August 14, 2023

Re: *Planning Development Comments – BOKF Albuquerque
Comment Responses to May 25, 2023 comments*

Wallace Design Collective has reviewed the transportation development comments. Our comment responses to the individual comments provided in the word document are as follows:

**PROPOSED  
PICKUP  
DEMOLITION  
&  
SITE PLAN**

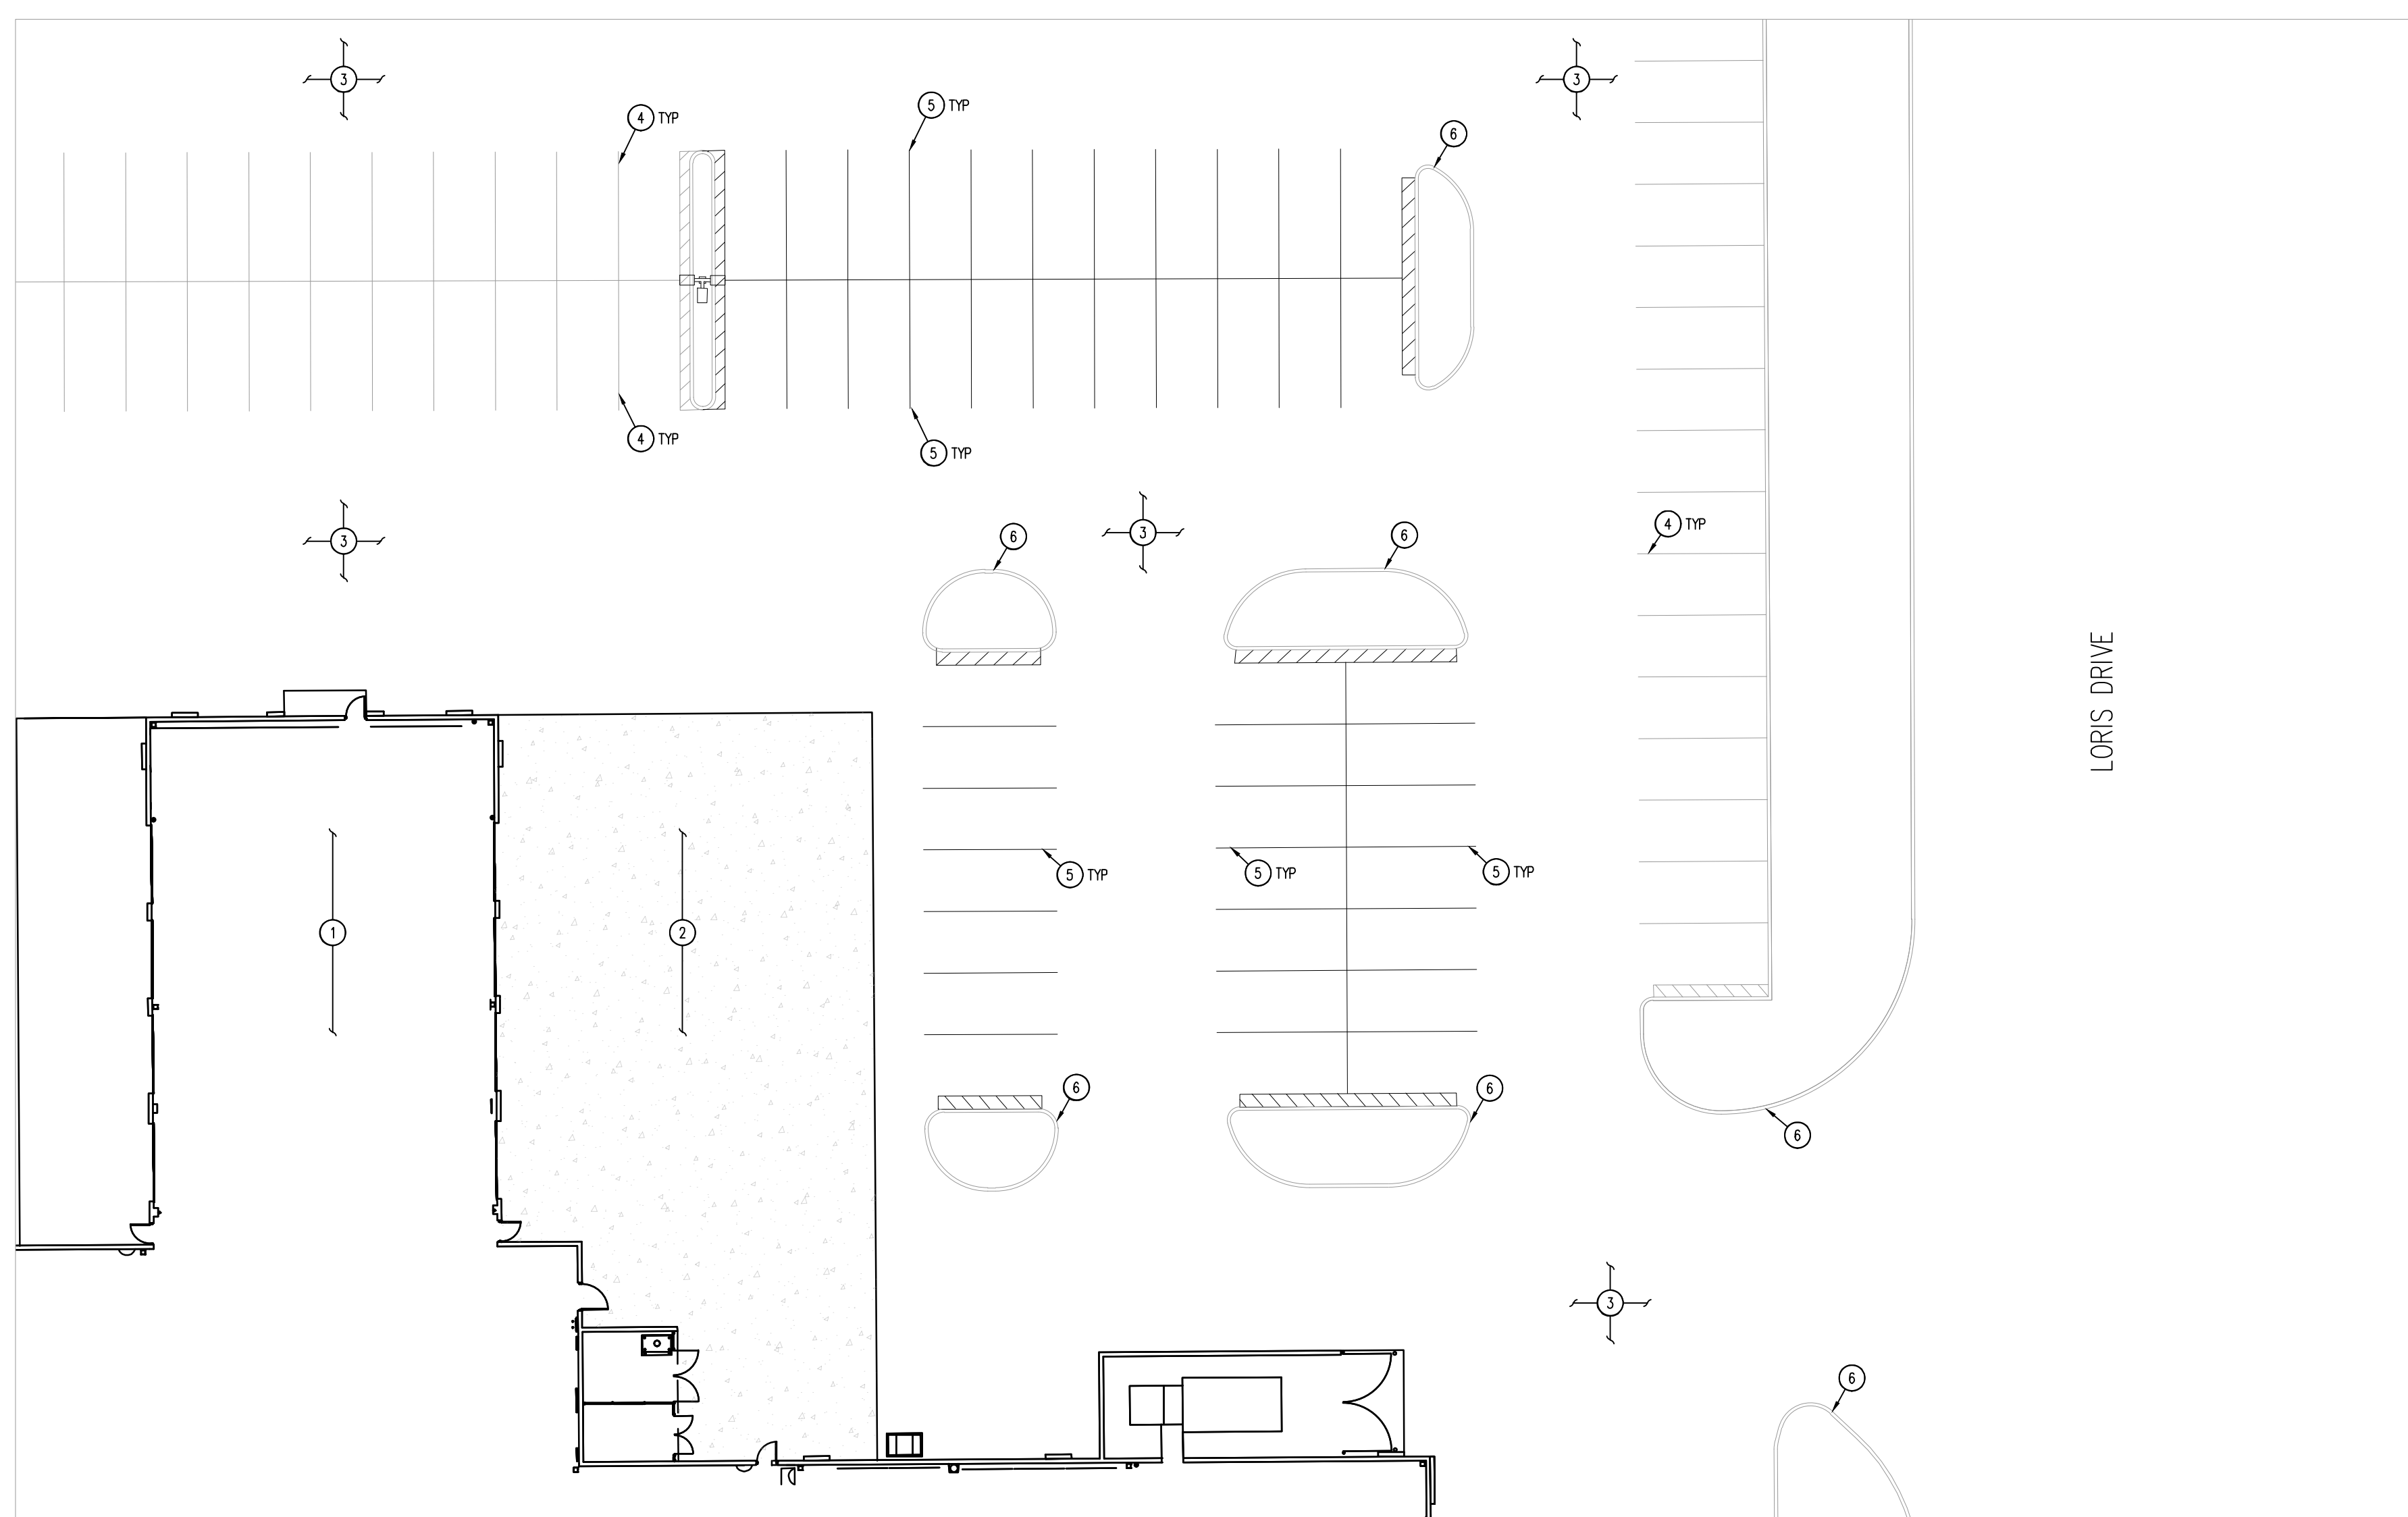
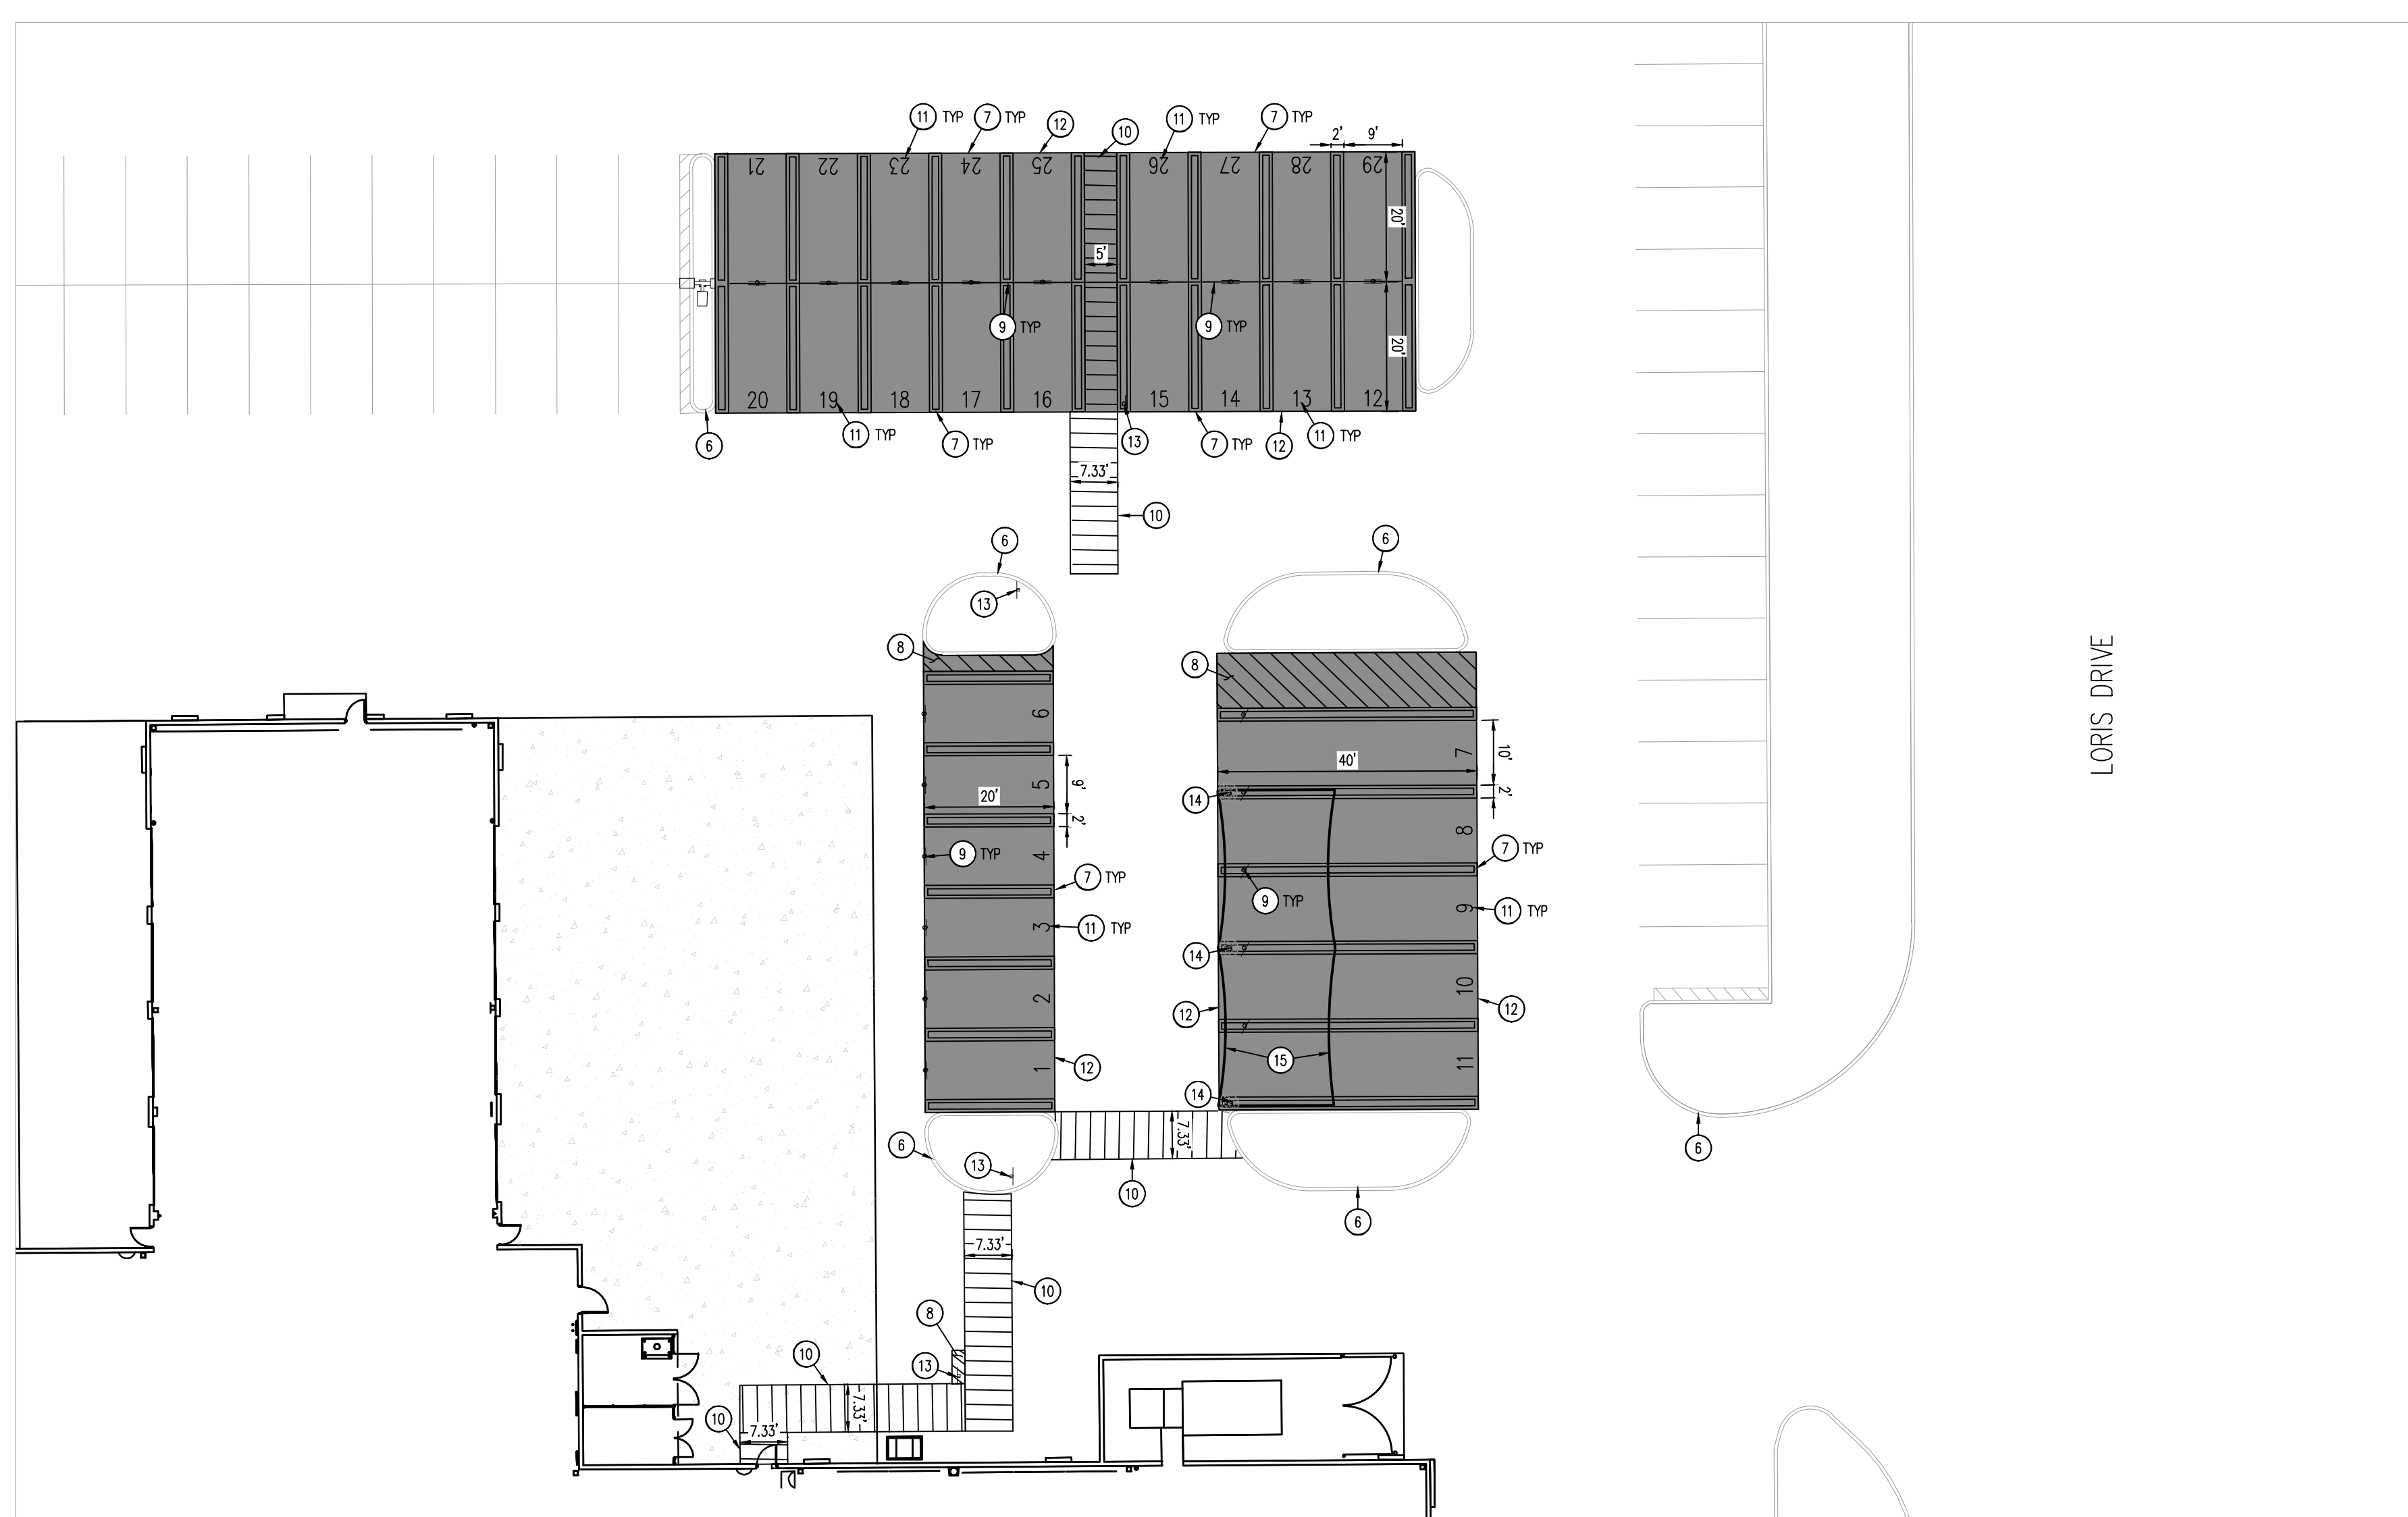
Parking is being reduced

(1.) Will it still be meeting the standards of the original plan?

(2.) Is the site subject to a shared parking agreement?

- *Response: Parking requirements will still be met. This building is now office space, which only requires 1 space/200 SF office. Since the building is 64,800 SF, 324 stalls are required. The site currently has 562 stalls. With only 42 stalls being removed, there will still be 520 stalls onsite.*

- *Response: Per the reciprocal easement agreement in document No. 2001016408, there is a reciprocal access agreement between tract C-3-B to the north and tract C-3-C (the site). The proposed site work requires removal of existing stalls at the south, so the northern stalls will not be affected by this development.*
